DEVELOPMENT REVIEW BOARD
TRANSPORTATION DEVELOPMENT

DRB Project Number: 004966
1419 Los Tomases

SUBJECT: Sketch Plat

Sketch Plat Review for: 1419 Los Tomases Dr NW; Albuquerque, NM 87102

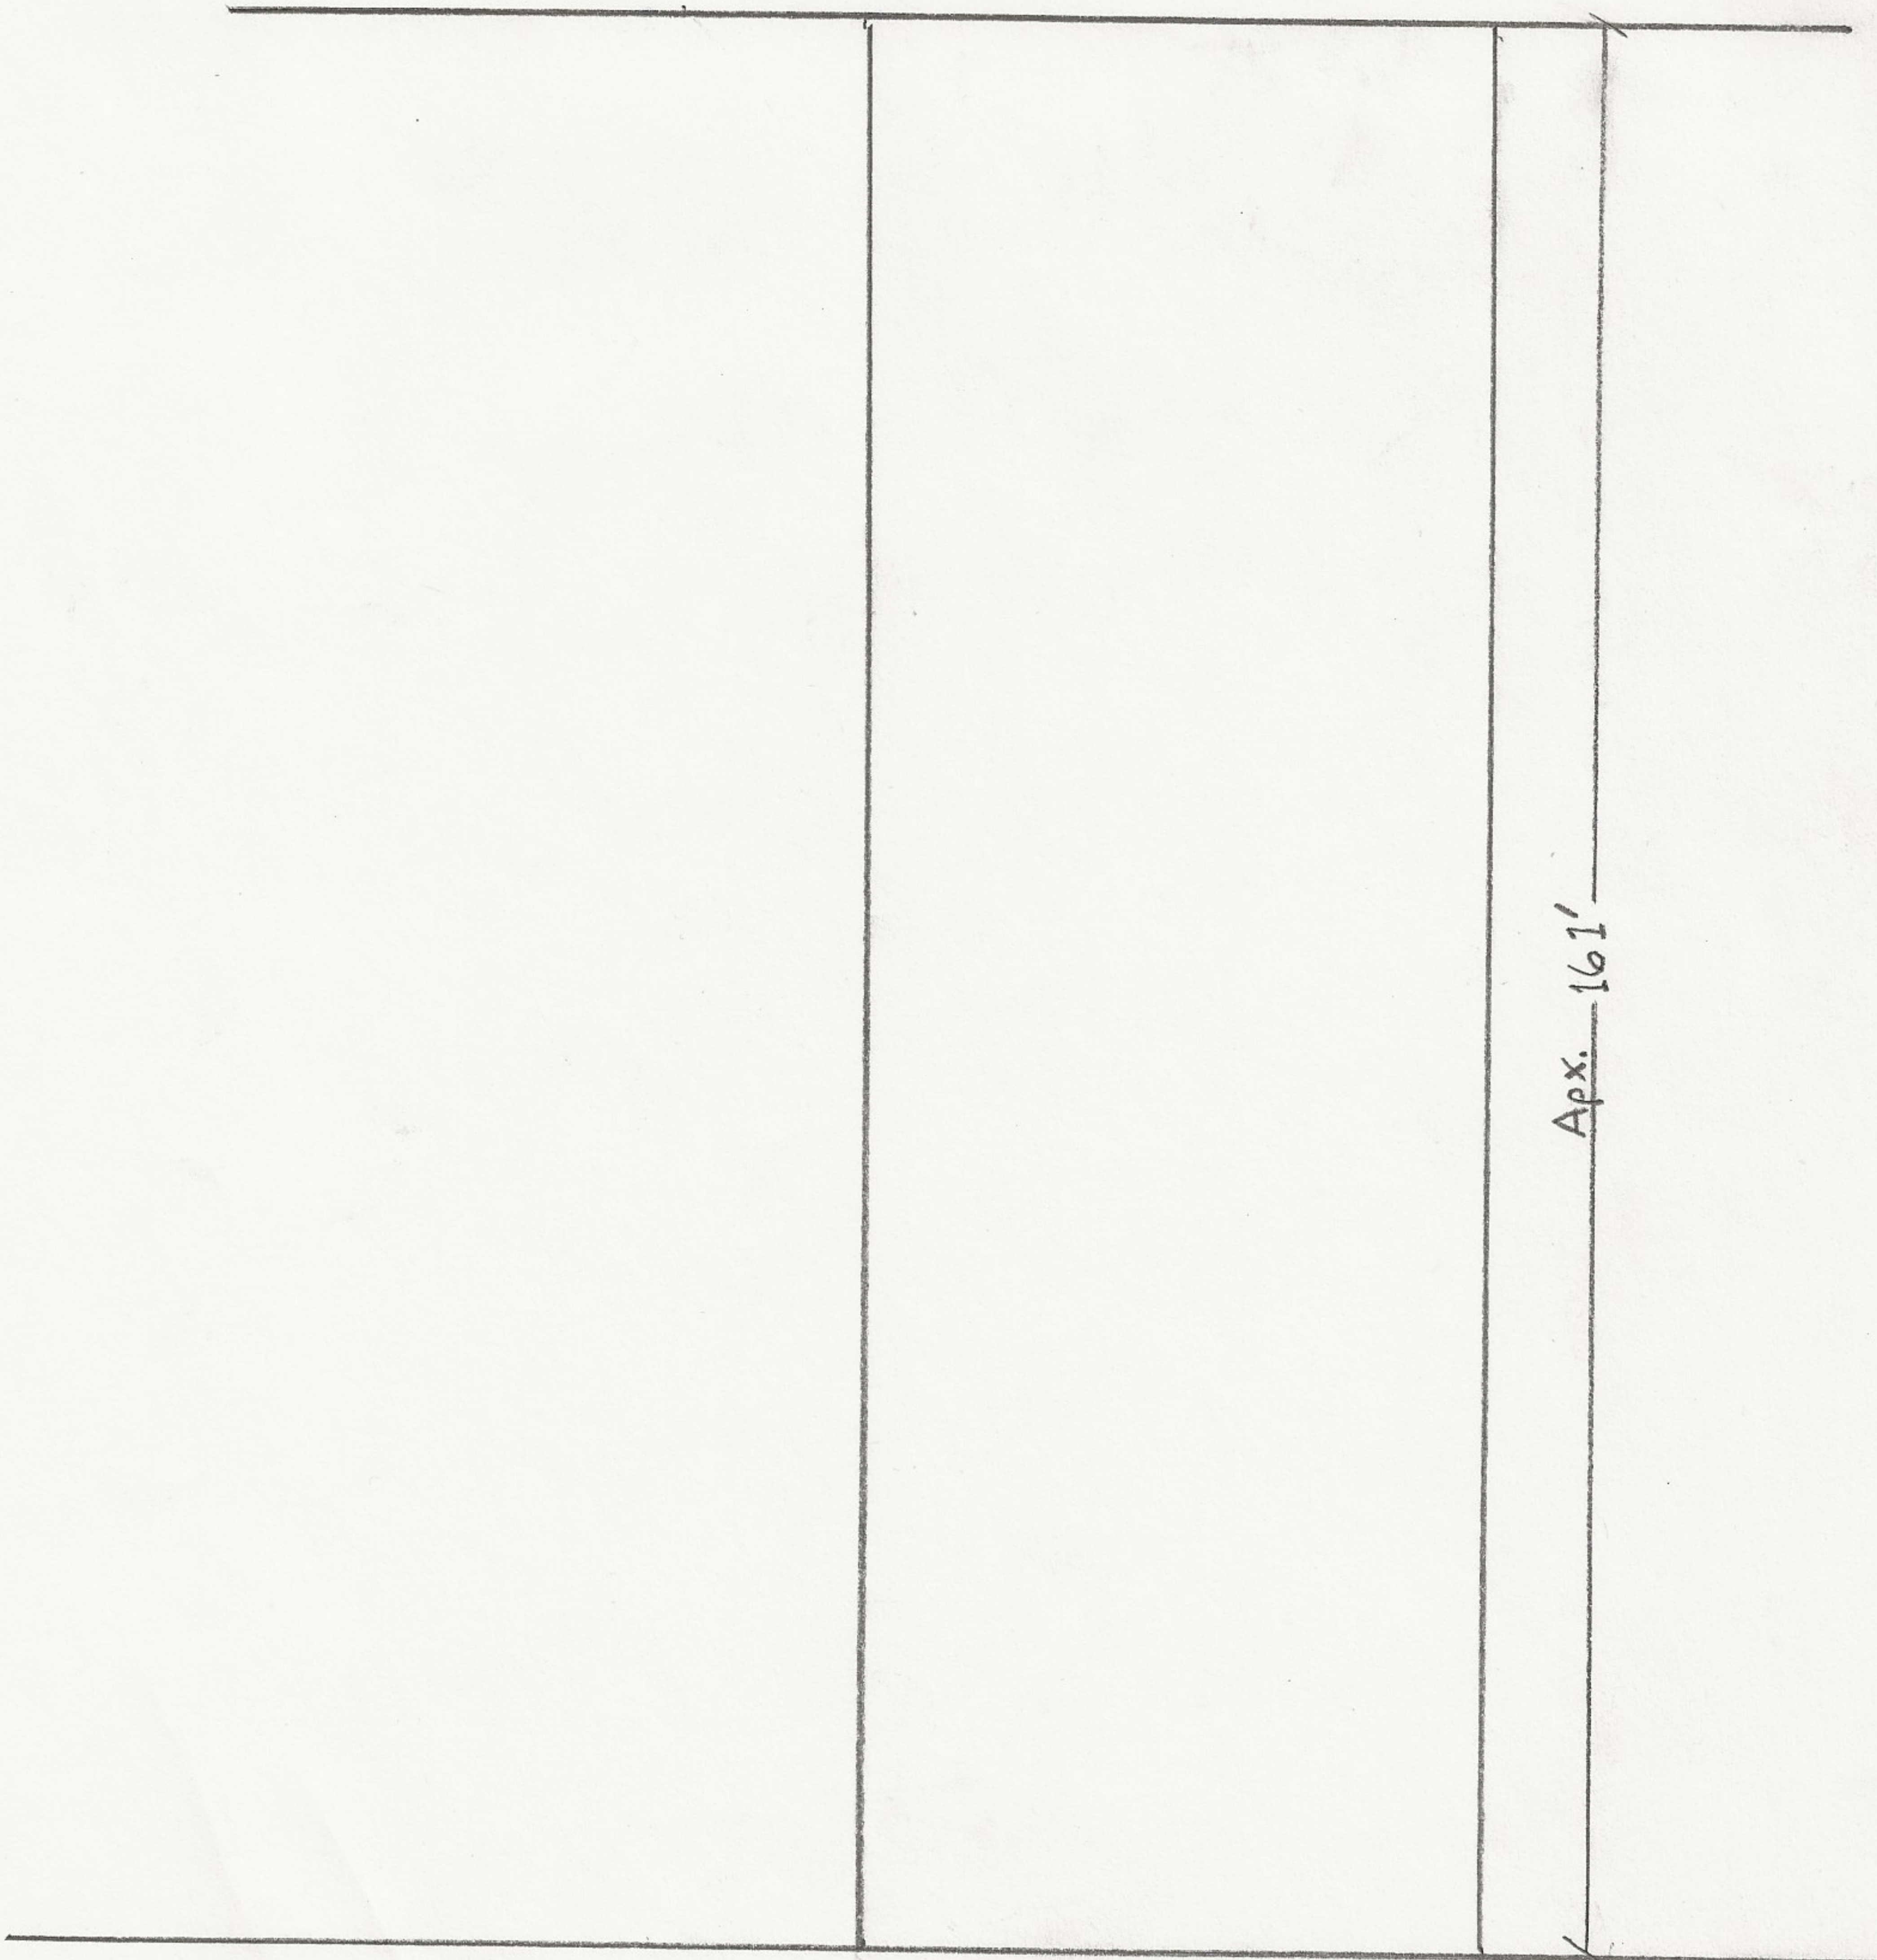
1. Label the existing right-of-way width and the existing sidewalk width on Los Tomases. A minimum 5-foot sidewalk is required along the frontage.
